Our Case Number: ABP-309770-21

Re: Proposed development of up to 15 wind turbines with a tip height of up to 175 metres and laying of approximately 26km of underground electricity cabling to facilitate the connection to the national grid, and all associated site development works
Townlands of Camagh, Carlanstown, Coole, Clonrobert, Clonsura, Doon, Monktown, Mullagh, Newcastle and other townlands, Co. Westmeath

Case reference: PA25M.309770:

Proposed development of up to 15 wind turbines with a tip height of up to 175 metres and laying of approximately 26km of underground electricity cabling to facilitate the connection to the national grid, and all associated site development works.

Figure 2. Proposed Coole Wind Turbines plotted in Radio Planning Software

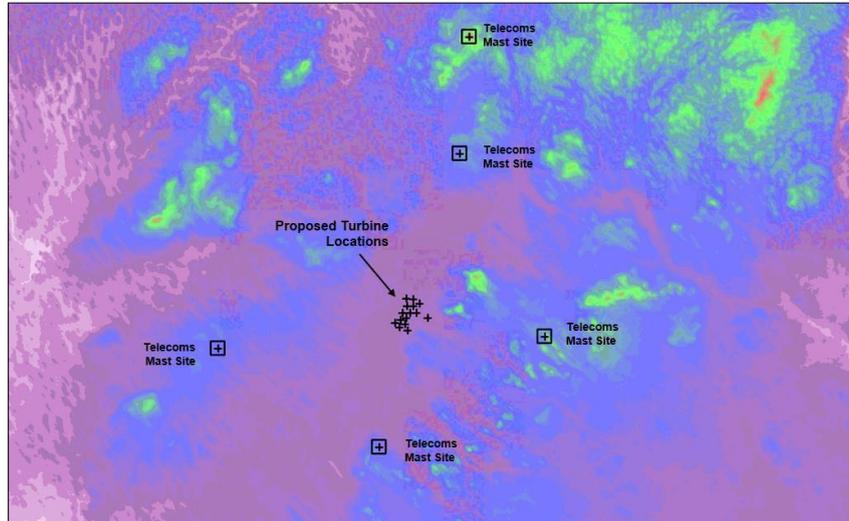
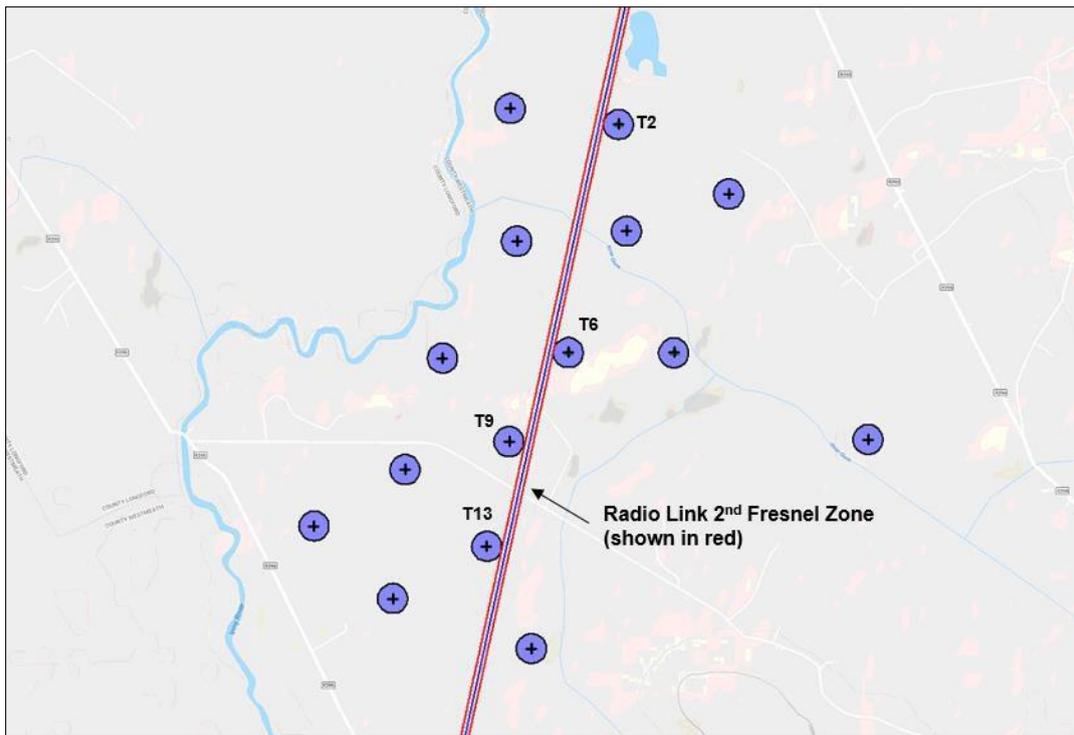
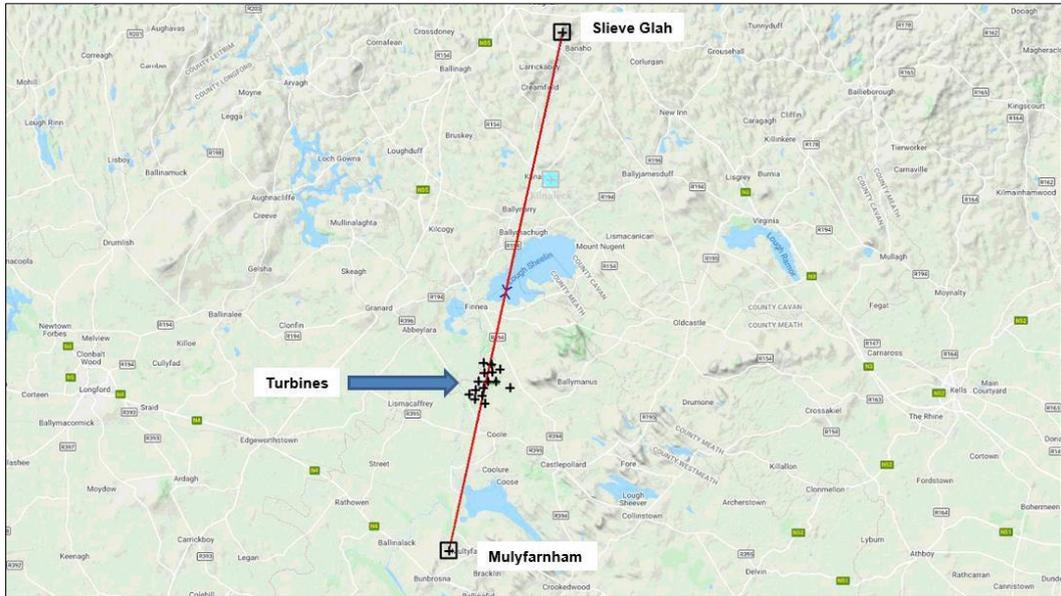
In fig. 3.2 it appears that turbines 2,6,,9 and 13 are in the path of the buffer zone for Three Ireland. Three Ireland has the best mobile phone connection in this area. It is not good, but is the only viable one locally. This now is to be destroyed by the turbines.

Remote working will be impossible in this area if the currently fair internet coverage is degraded by blockage from the turbines. Turbine no 11 is just within the buffer zone of at least one residence.
